TfNSW Reference: SYD21/00232/06

DPIE Reference: SSD-15221509

**EXHIBITION OF EIS - WOOLWORTHS WAREHOUSE & DISTRIBUTION CENTRE
250 VICTORIA STREET, WETHERILL PARK**

Attachment A

26.0m B-DOUBLE VEHICLE
SWEPT PATHS

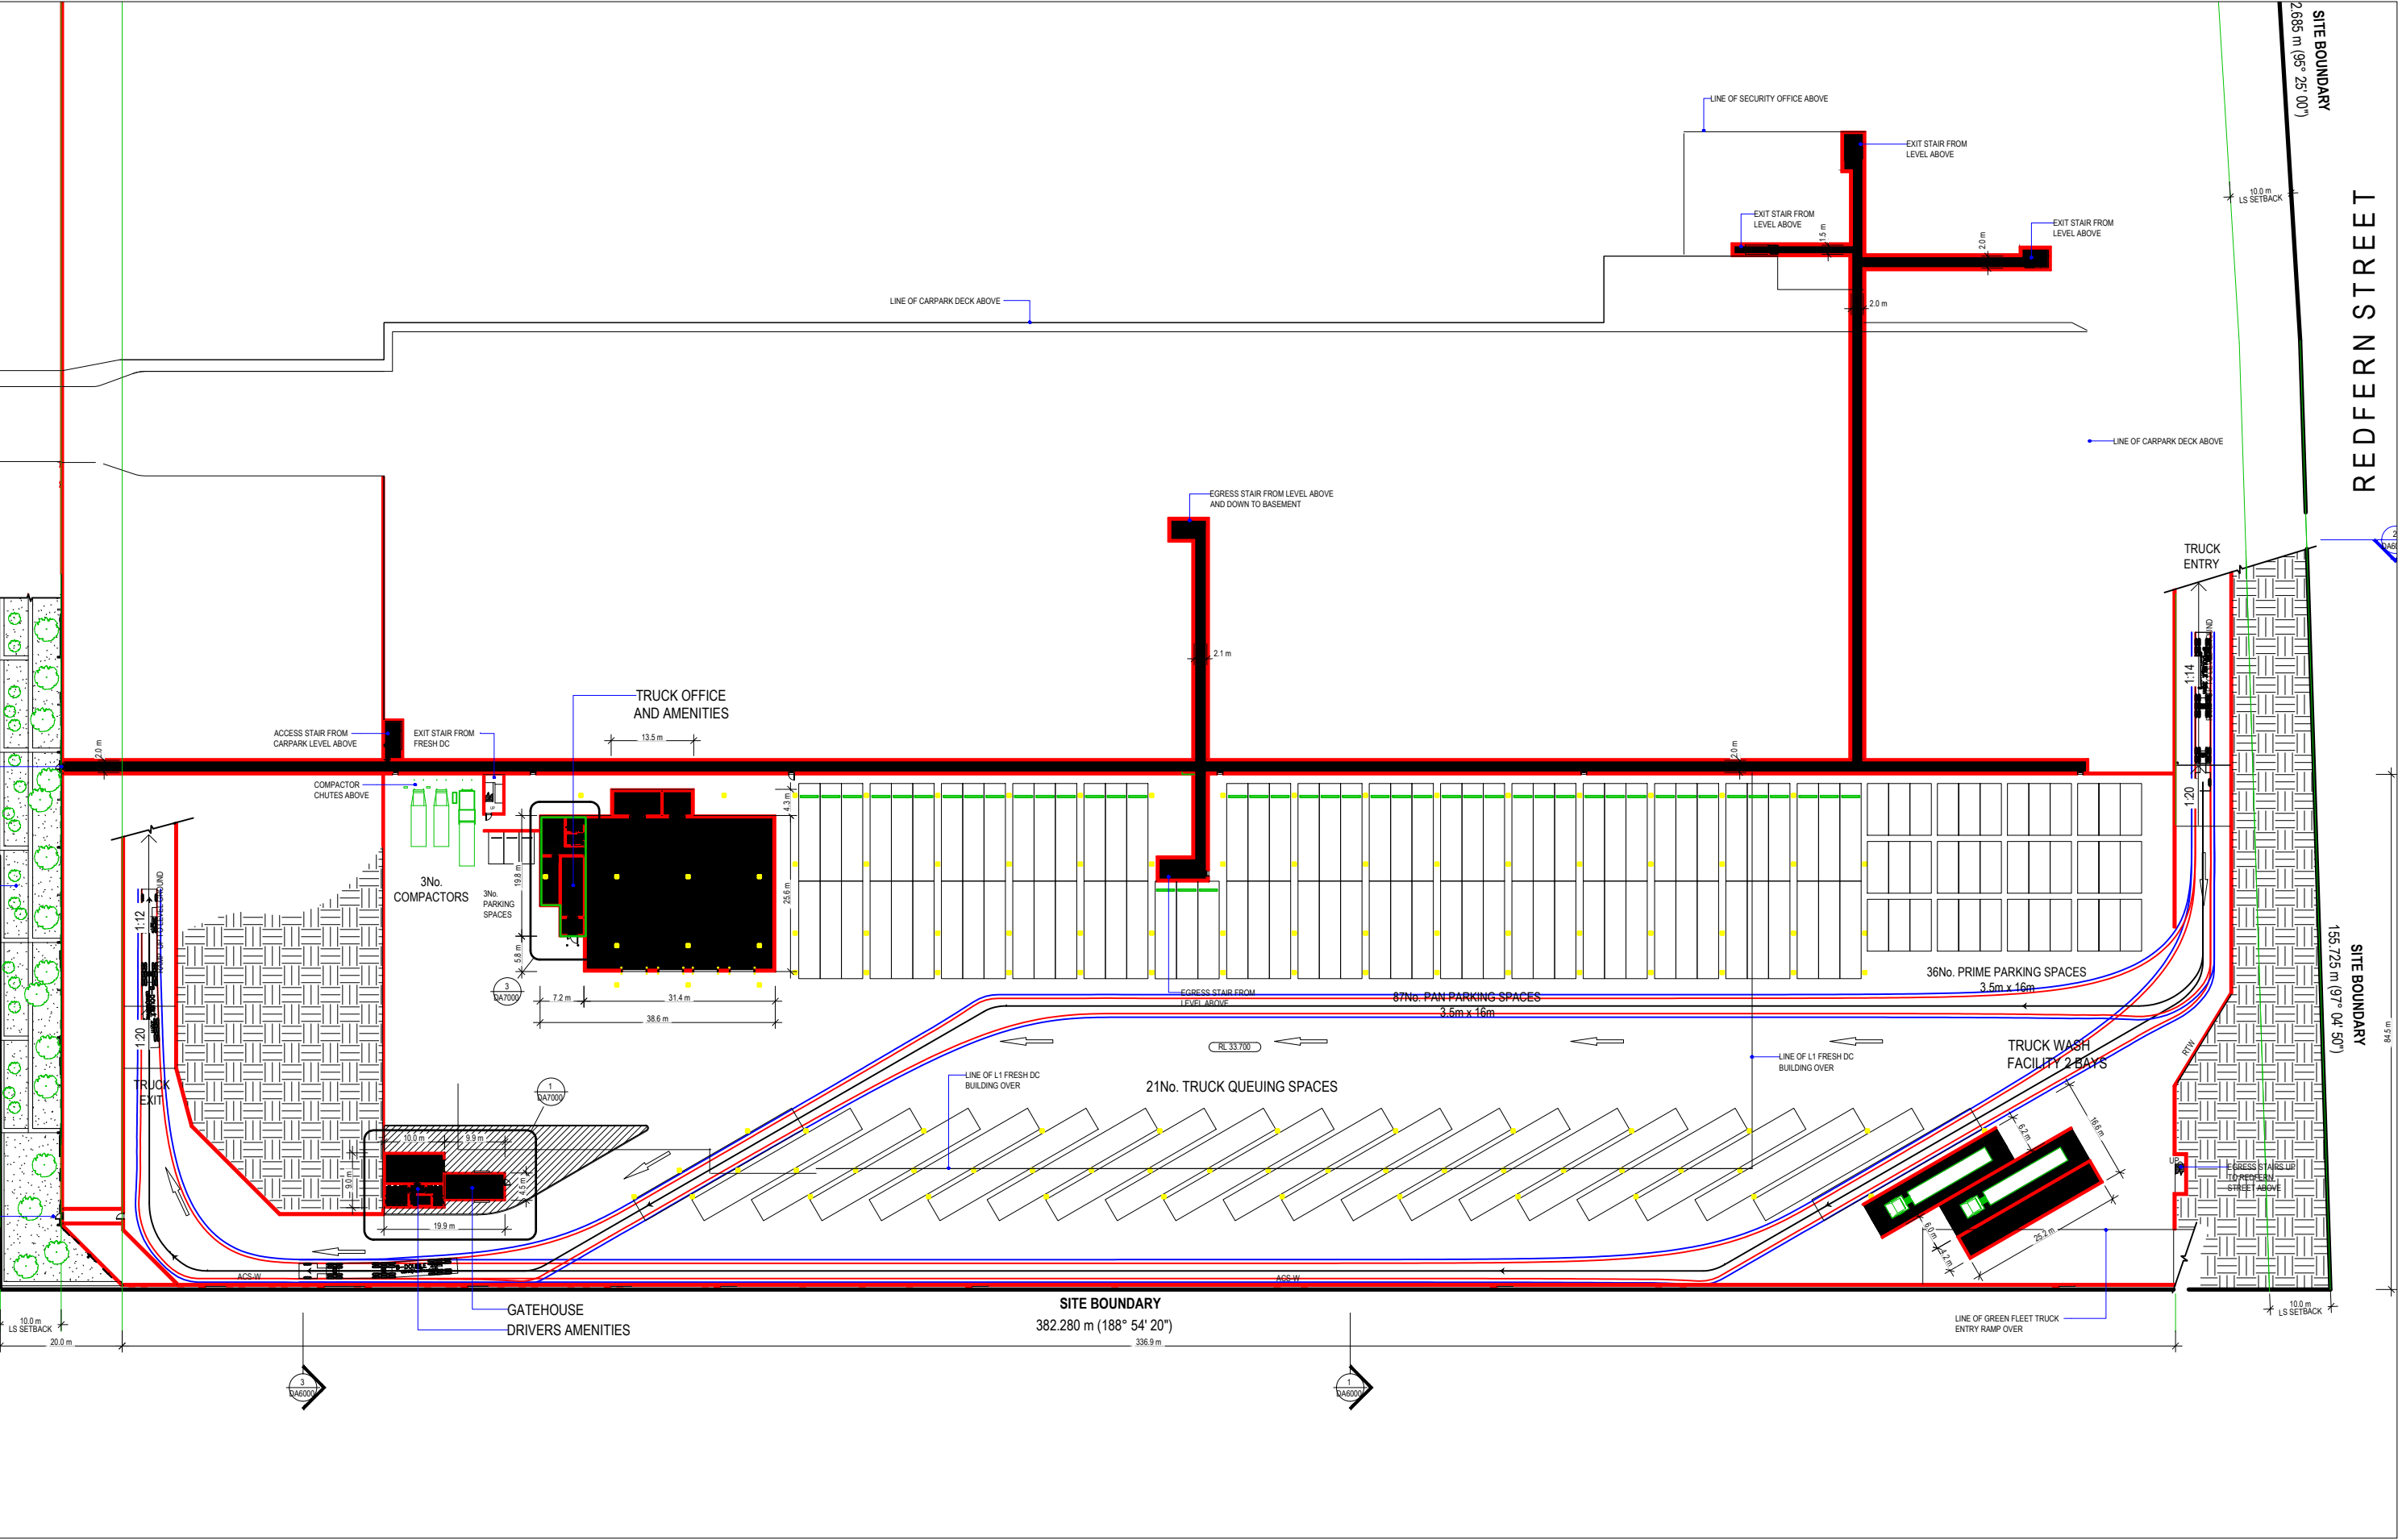
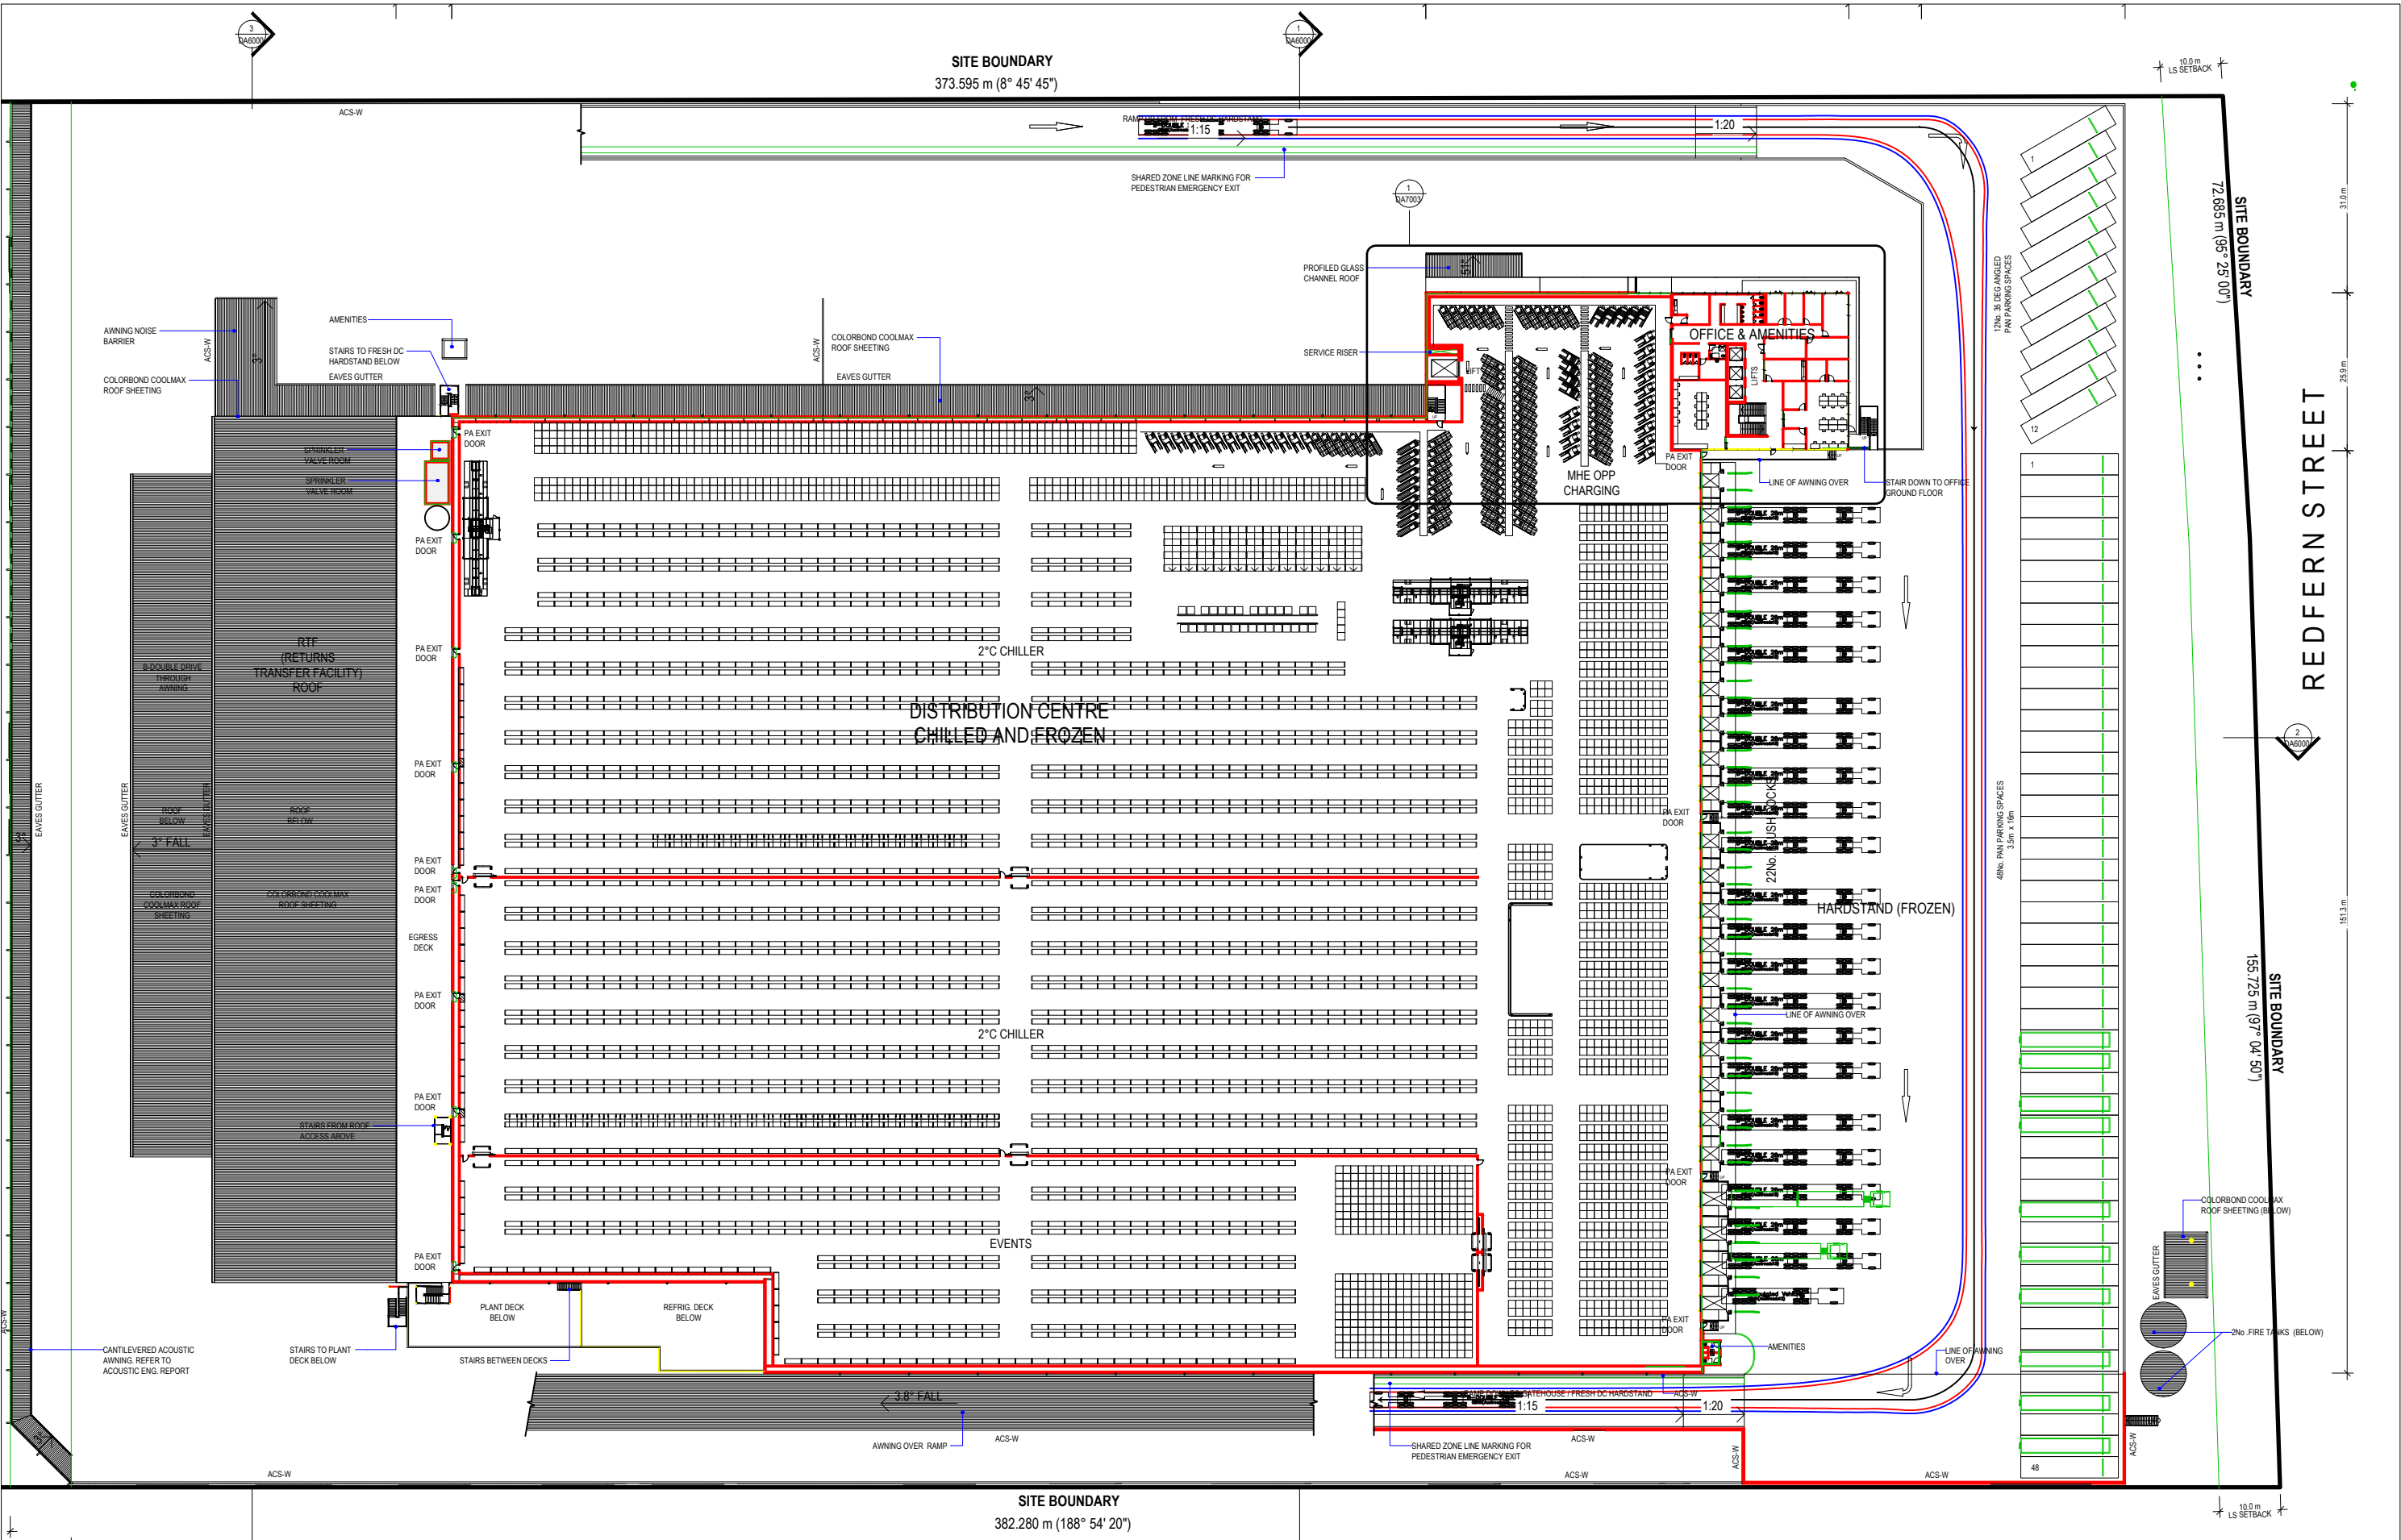
Swept path analysis should be provided for the longest vehicle accessing the site from Victoria Street and demonstrate how simultaneous entry/exit can be achieved at the proposed access.

- Confirmation whether the anticipated number of truck movements generated by the proposal made any assumptions on the use of Higher Mass Limit (HML) vehicles. Both Redfern and Walter Streets are currently not approved for HML short combination nor HML B-Double access.
- Confirmation whether there are any proposed boom gates or access gates for heavy vehicles entering the site as this could potentially cause queuing of heavy vehicles onto Redfern Street.
- Confirmation whether B-double decoupling areas are needed so that both the 'A' and 'B' trailers can be unloaded from the rear. The swept path diagrams show the full B-double combination approaching and departing the loading docks.
